February 2, 2018

**Subject: WindingWalk PUD Development Plan/Preliminary Plan and Filing No. 1 Final Plat (PUDSP-18-002, SF-18-002)**

The Planning Division of the Community Services Department has reviewed the WindingWalk PUD Development Plan/Preliminary Plan and Filing No. 1 Final Plat, and has the following comments of behalf of El Paso County Parks. This application will be presented to the Park Advisory Board February 14, 2018.

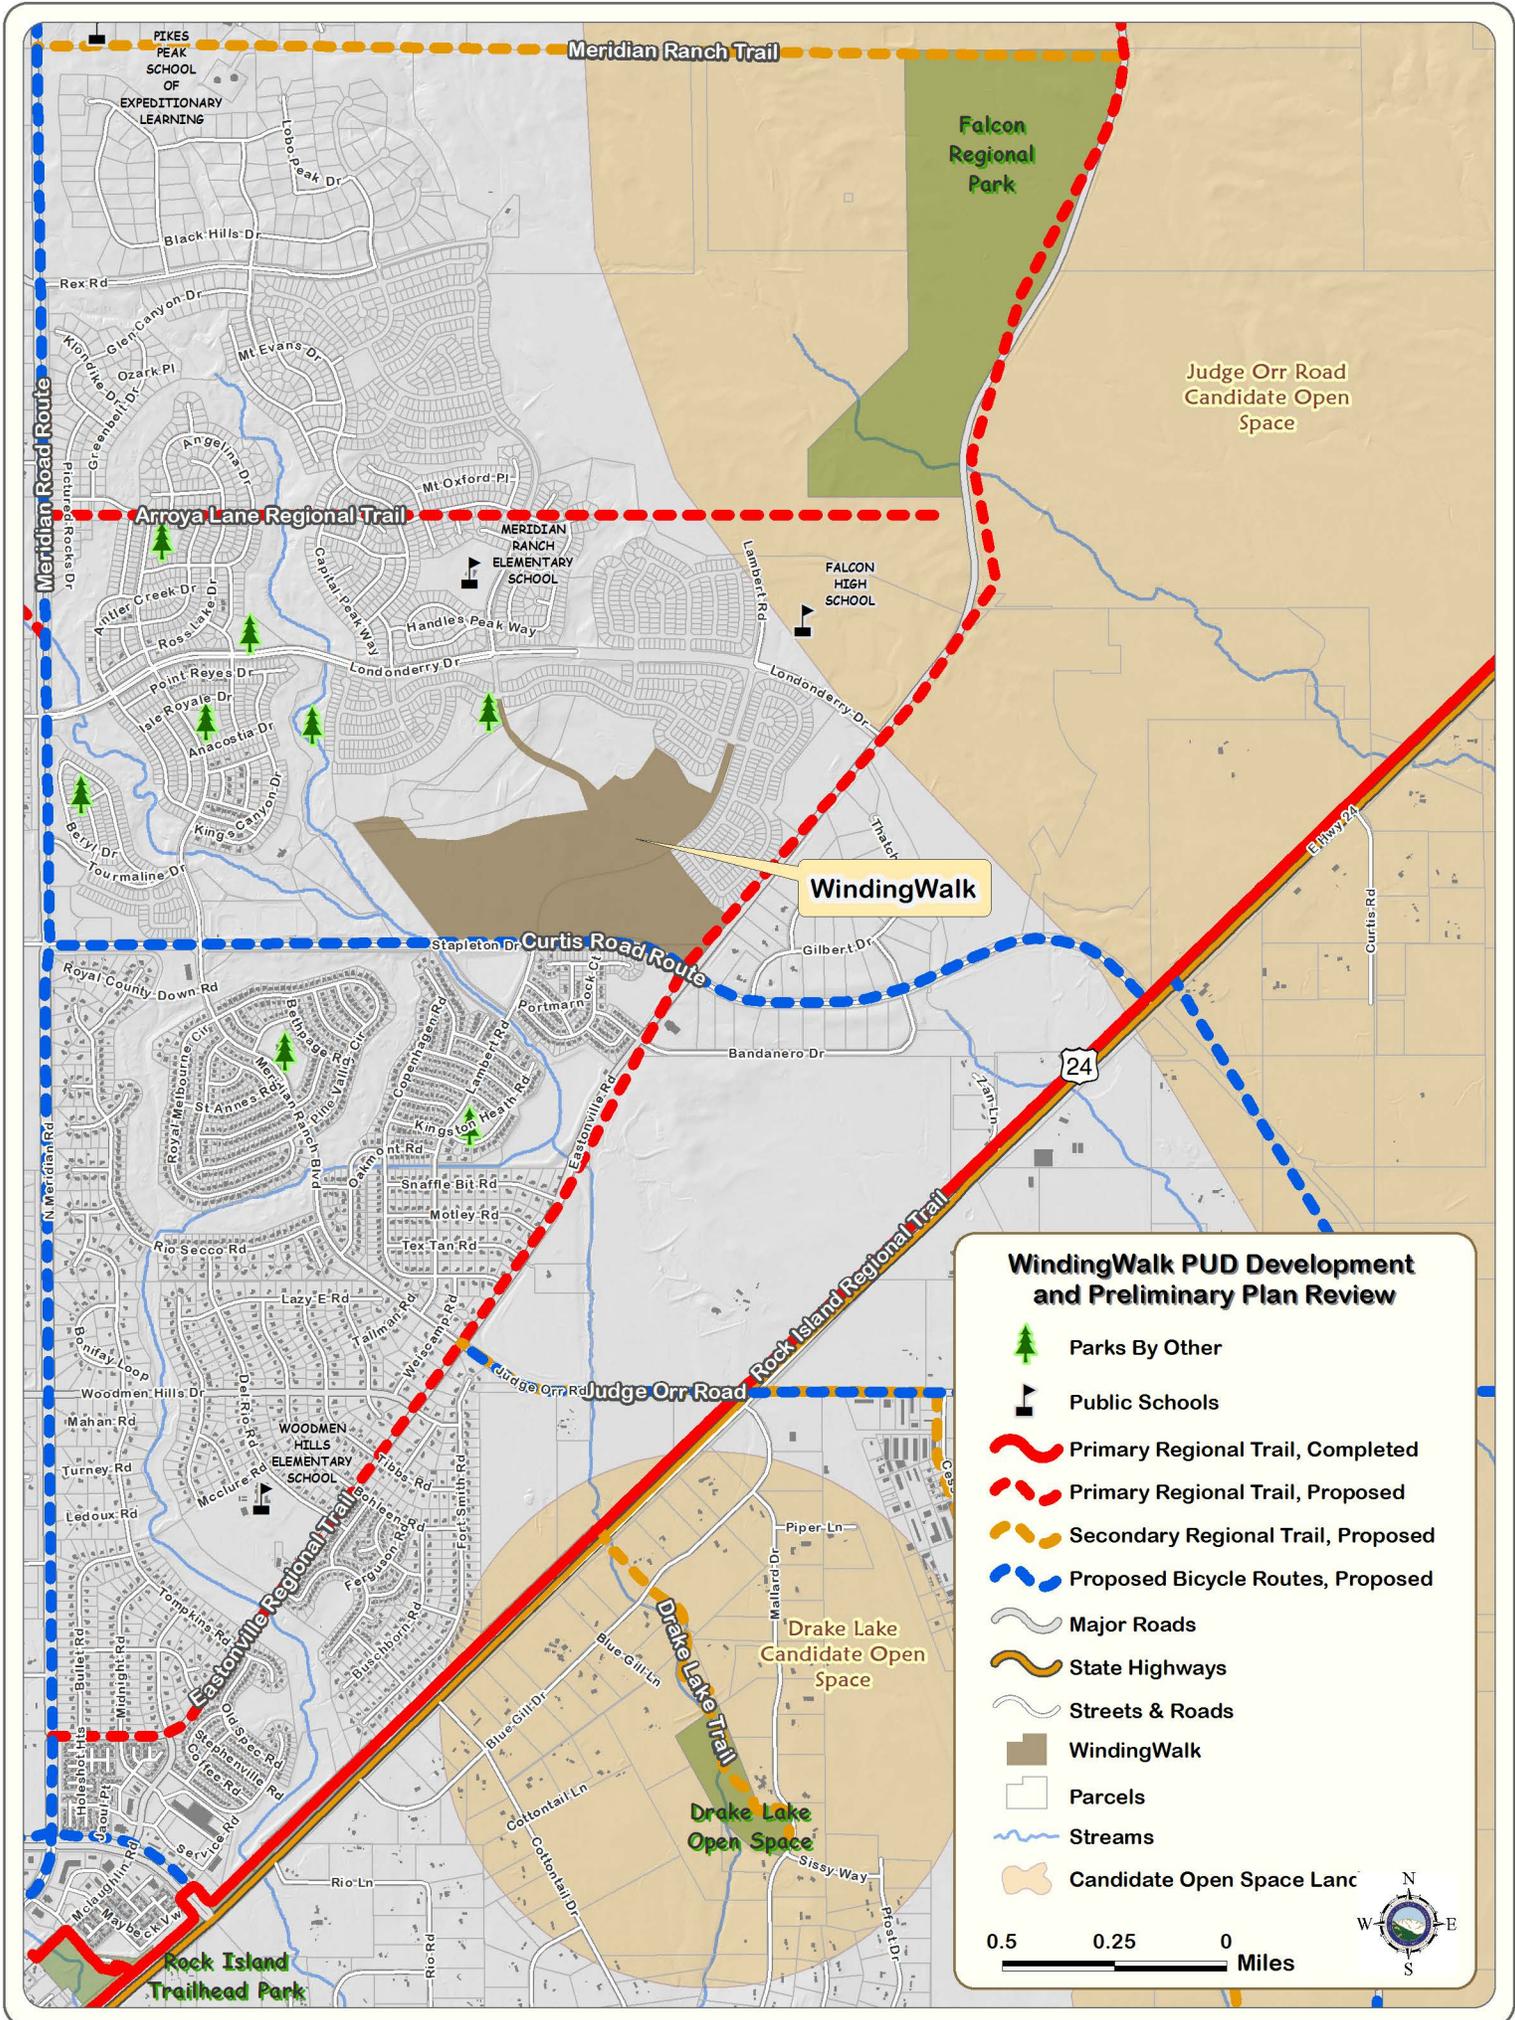
- Regional fees are not required pursuant to the existing park lands agreement for regional park land dedication.
- As stated in the general notes of the approved 2015 Meridian Ranch Sketch Plan Amendment, the landowner shall dedicate to El Paso County a 25' trail easement along Eastonville Road that allows for public access, as well as construction and maintenance of a primary regional trail, and the aforementioned easement be shown on the PUD Development Plan / Preliminary Plan, and shall be shown and dedicated on the Final Plat.
